**KIRKLEES METROPOLITAN COUNCIL
INVESTMENT & REGENERATION SERVICE**

DELEGATED DECISION TO DETERMINE PLANNING APPLICATIONS

Reference No:	2023/62/90576/E
Site Address:	East Bierley Cricket Club, South View Road, East Bierley, BD4 6PJ
Description:	Erection of extensions and refurbishment of tea room and changing rooms and upgrade to existing terrace.
Recommending Officer:	Nicole Helliwell

Officer Report

Site Plan- Proposed

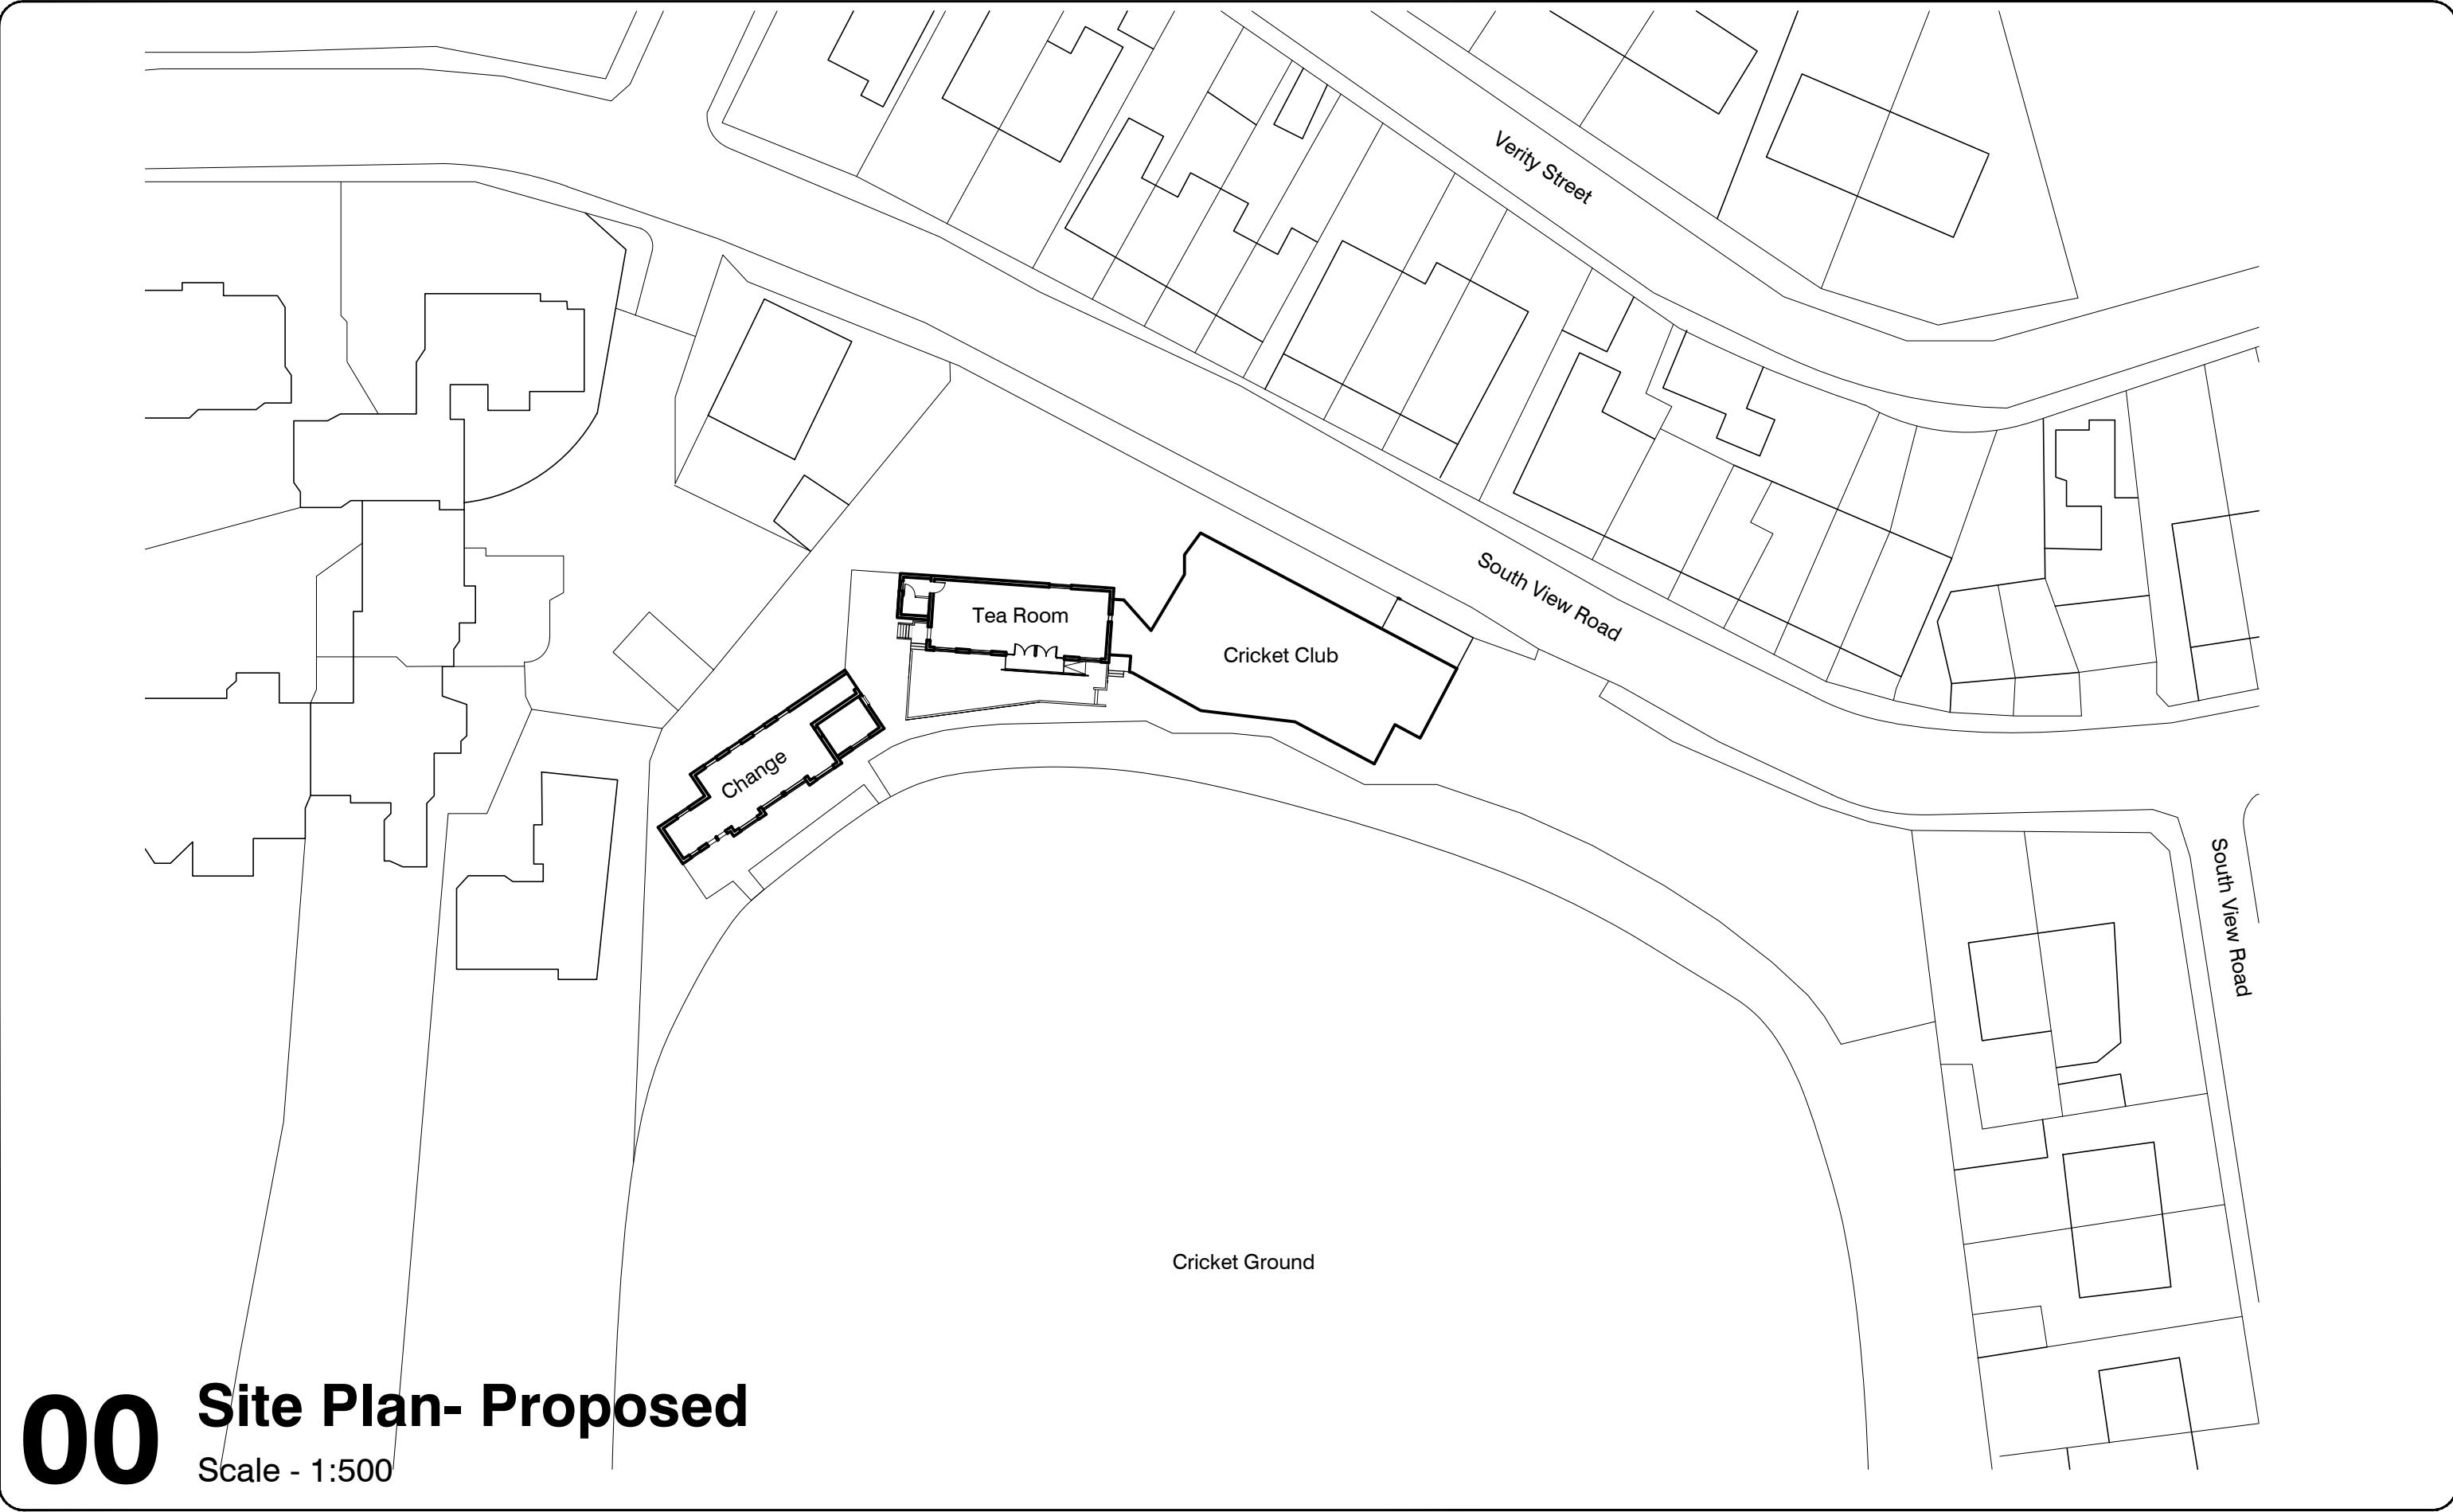
The Statement goes on to describe a new decking area to the rear of the building, this is situated on the north face of the club house, facing the road, a neighbouring residential property and houses directly across the road. The existing terraces to the clubhouse are on the south elevation appear to be extensive in size and face the cricket pitch. The nearest sensitive receptor is within 15m of the proposed new decked area. We have concerns that noise and disturbance by customers using the proposed new decked area to the north elevation will impact the amenity of nearby sensitive receptors and that the new French doors from the clubhouse to this decked area will allow break

out noise from activities within the club house if left open, we therefore cannot support these elements of the proposed development.

Environmental Health expressed concerns regarding noise and disturbance. The customers using the proposed new decked area to the north elevation would impact the amenity of nearby sensitive receptors. Furthermore, the new French doors from the clubhouse to this decked area would allow break out noise from activities within the club house if left open. Whilst Environmental Health did confirm that they would not support these elements of the proposal, the rear decking and patio doors have since been omitted from the application and as such there are no concerns.

Amendments were sought during the course of the application. A request was made to omit the rear decking from the planning application and remove the patio doors to the rear elevation of the Tea Room. Revised drawings were received which were considered acceptable from a residential amenity perspective. The description was also altered to reflect the revised proposal.
